DISAPPROVED
Plan Review
08/19/2019 3:08:19 PM
d.despinoza
EPC Planning & Community
Development Department

SFD191035
PLAT: 0
ZONE: RR-5
AREA: 36.2 AC
DIST: 1

BILLIARD Residence Ensign Design, llc
5980 Burgess Road
Colorado Springs, COLORADO
EL PASO COUNTY
www.EnsignDesign.net

C1.1b
SITE PLAN

**C1.1b**  
 SITE PLAN

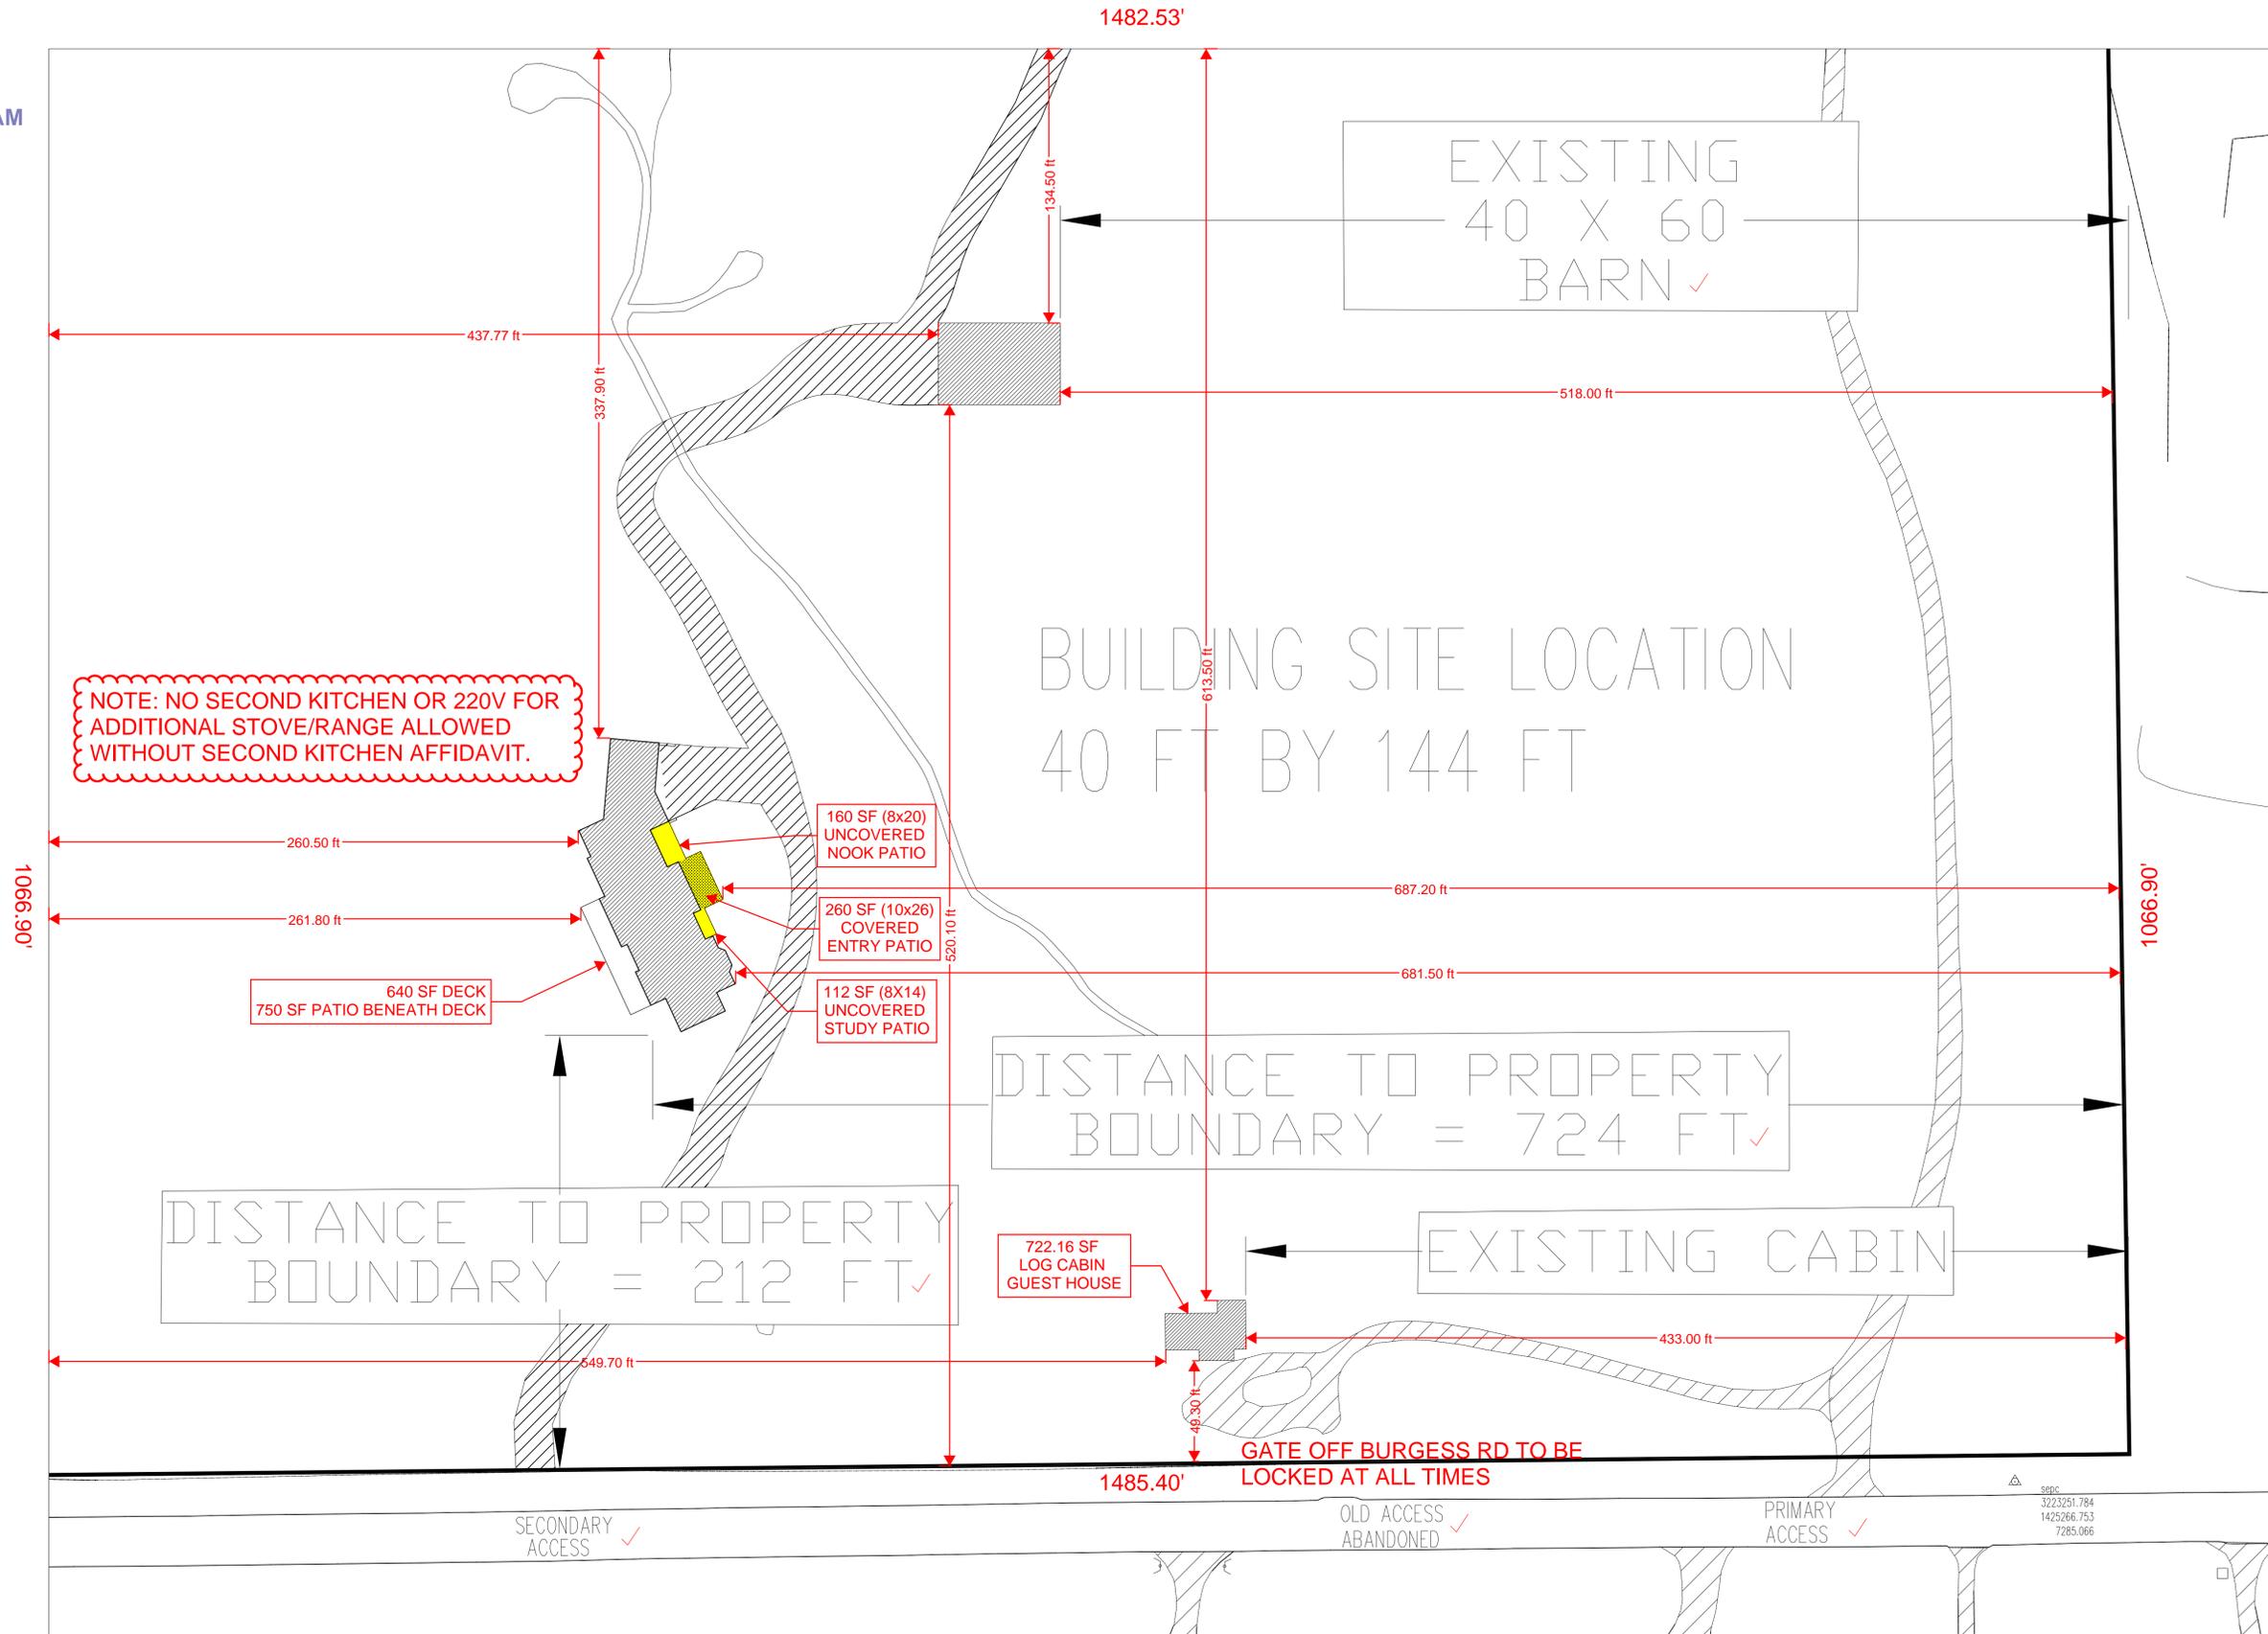
CONFIGURATION & AREA OF EXISTING CABIN DEPICTED ON SITE PLAN DOES NOT MATCH CURRENT ASSESSOR'S DATA & SKETCH AREA TABLE DATED 2/16/17.
